PROJECT: BOYLE RESIDENCE
DRAWING TITLE: MERCER ISLAND, WA
GENERAL NOTES

PERMIT SET

**BOYLE RESIDENCE
 MERCER ISLAND, WA
 FOUNDATION & FIRST FLOOR
 FRAMING PLANS**

PROJECT	BOYLE RESIDENCE
DRAWING TITLE	FOUNDATION & FIRST FLOOR FRAMING PLANS
DATE	07/25/17
REVISION	
SHEET NO.	S2.1

1/4" = 1'-0"

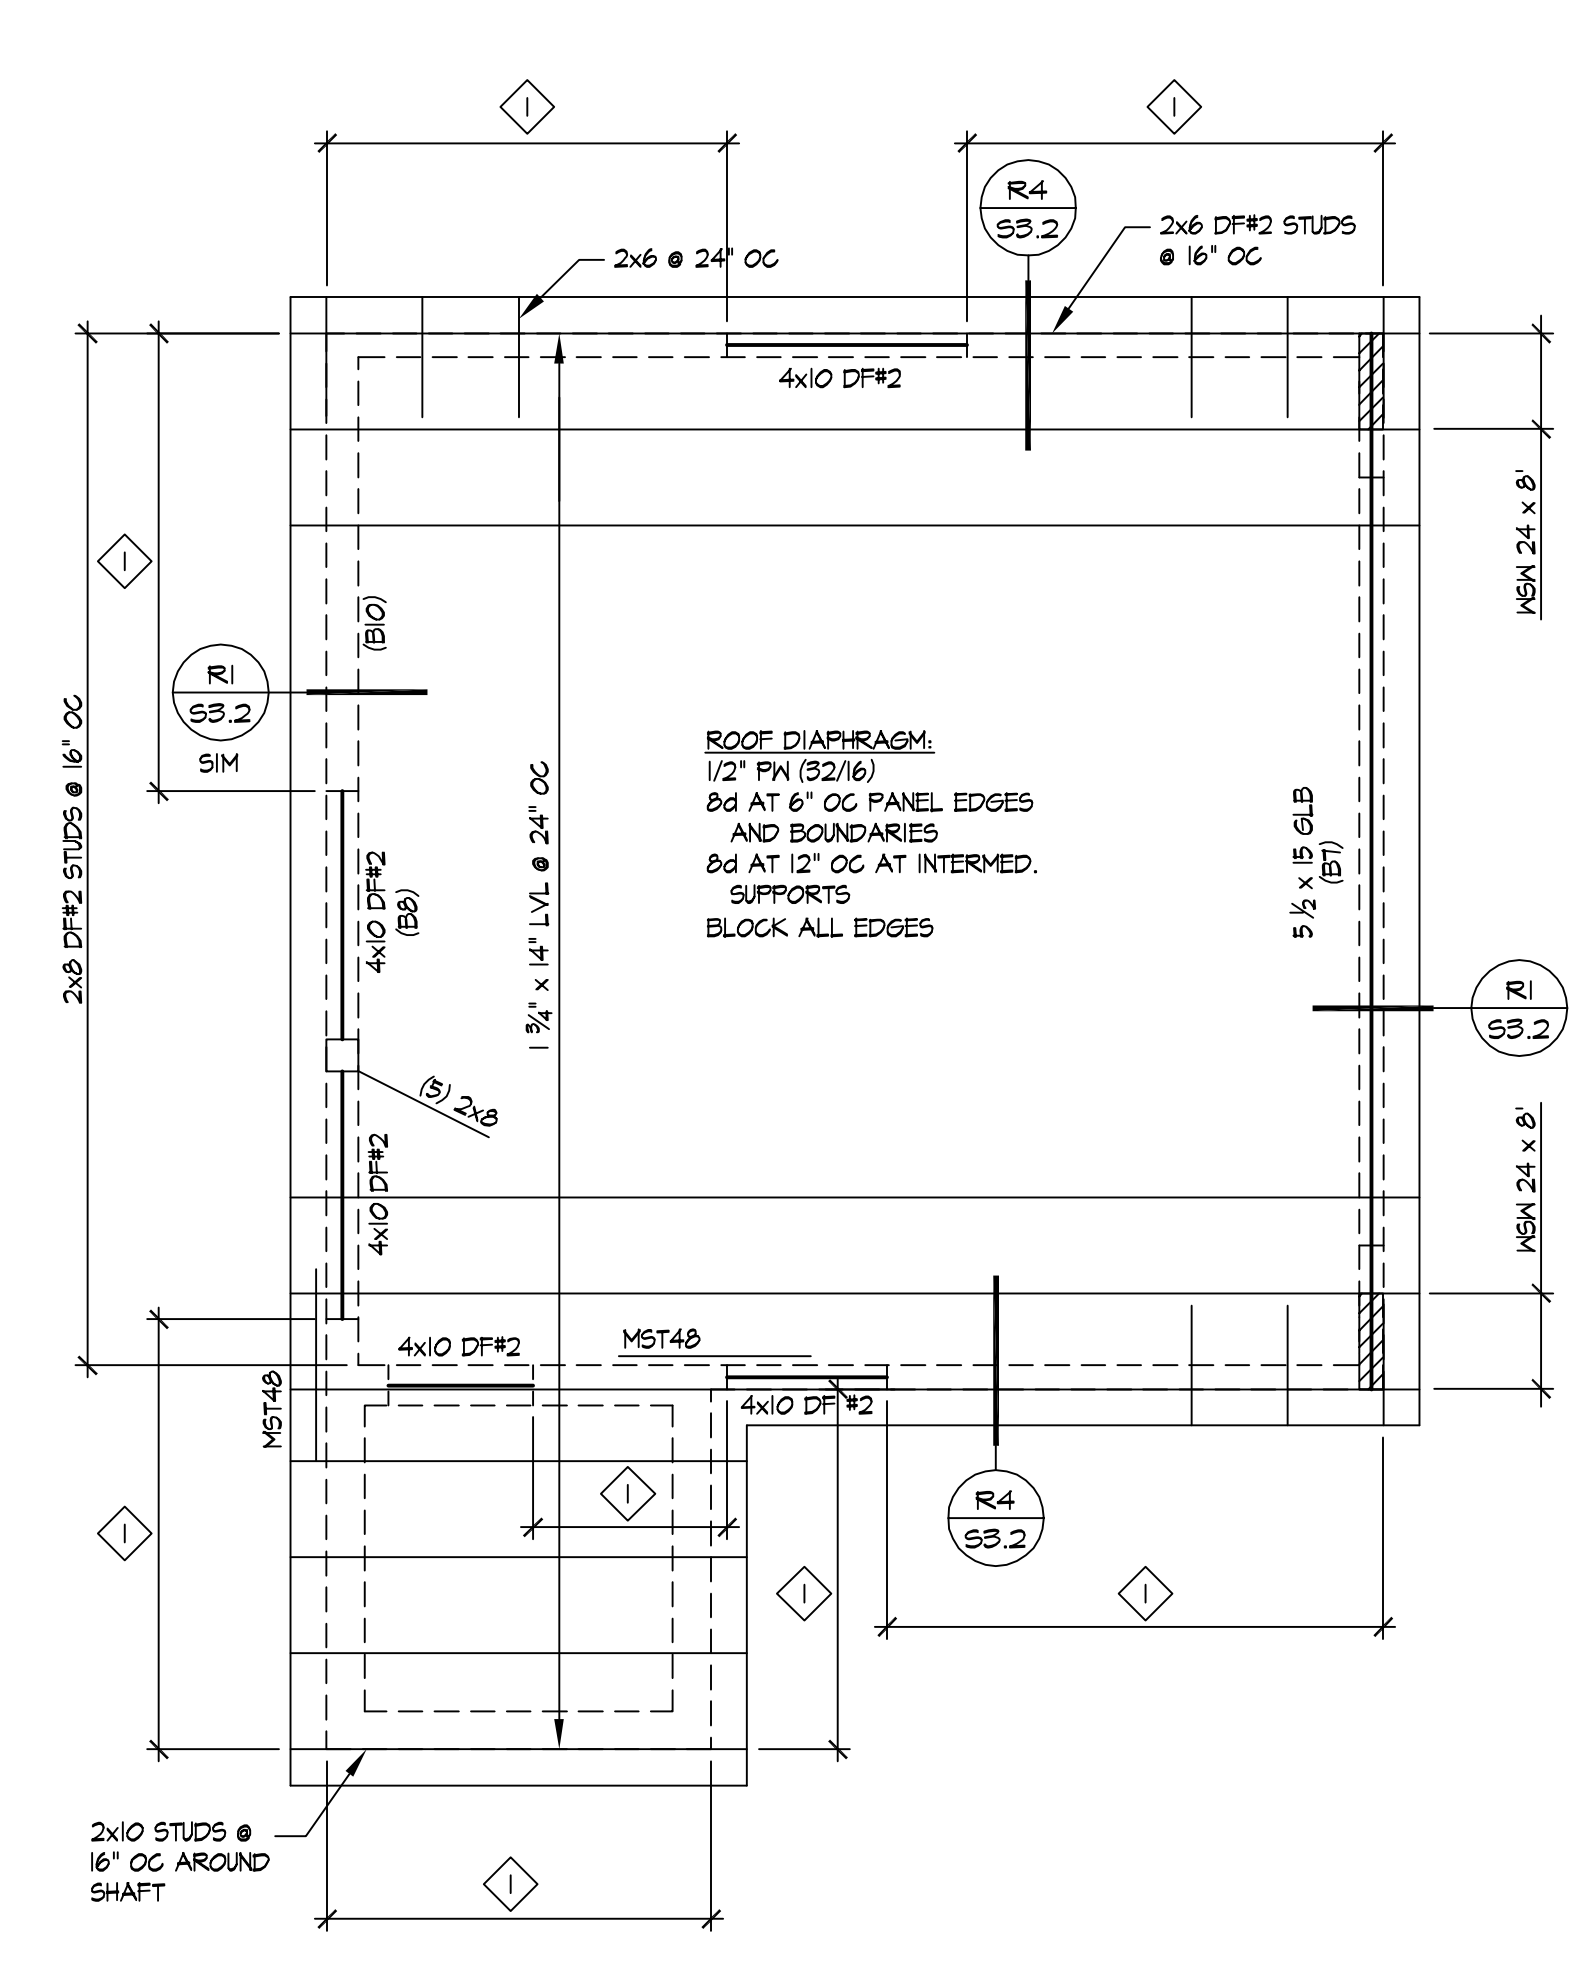
Building Review (paul.skidmore@mercergov.org)
Comment #1
Provide detail showing how portions of structure are "interconnected" as required by ASCE Section 12.1.3. Provide appropriate attachment between separate elements of the structure as required. Alternatively, provide appropriate separation joint between building portions as required by ASCE Section 12.12.3.

Building Review (paul.skidmore@mercergov.org)
Comment
Provide complete structural calculations and detailing for concrete elevator shaft. If intended to resolve lateral forces, provide special reinforced concrete shearwall design per ACI 318 Section

Building Review (paul.skidmore@mercergov.org)
Comment
Provide positive lateral connection for deck to main structure. DTT2Z are noted, but are not capable of developing code required forces.

Building Review (paul.skidmore@mercergov.org)
Comment #1
Provide detail showing how portions of structure are "interconnected" as required by ASCE Section 12.1.3. Provide appropriate attachment between separate wings as required. Alternatively, provide appropriate separation joint between building portions as required by ASCE Section

Building Review (paul.skidmore@mercergov.org)
Comment
Confirm by calculation capacity of ledger to resolve point load from 6x12 beam.

Building Review (paul.skidmore@mercergov.org)
Comment
Provide detail / elevation callout for WSW. Indicate
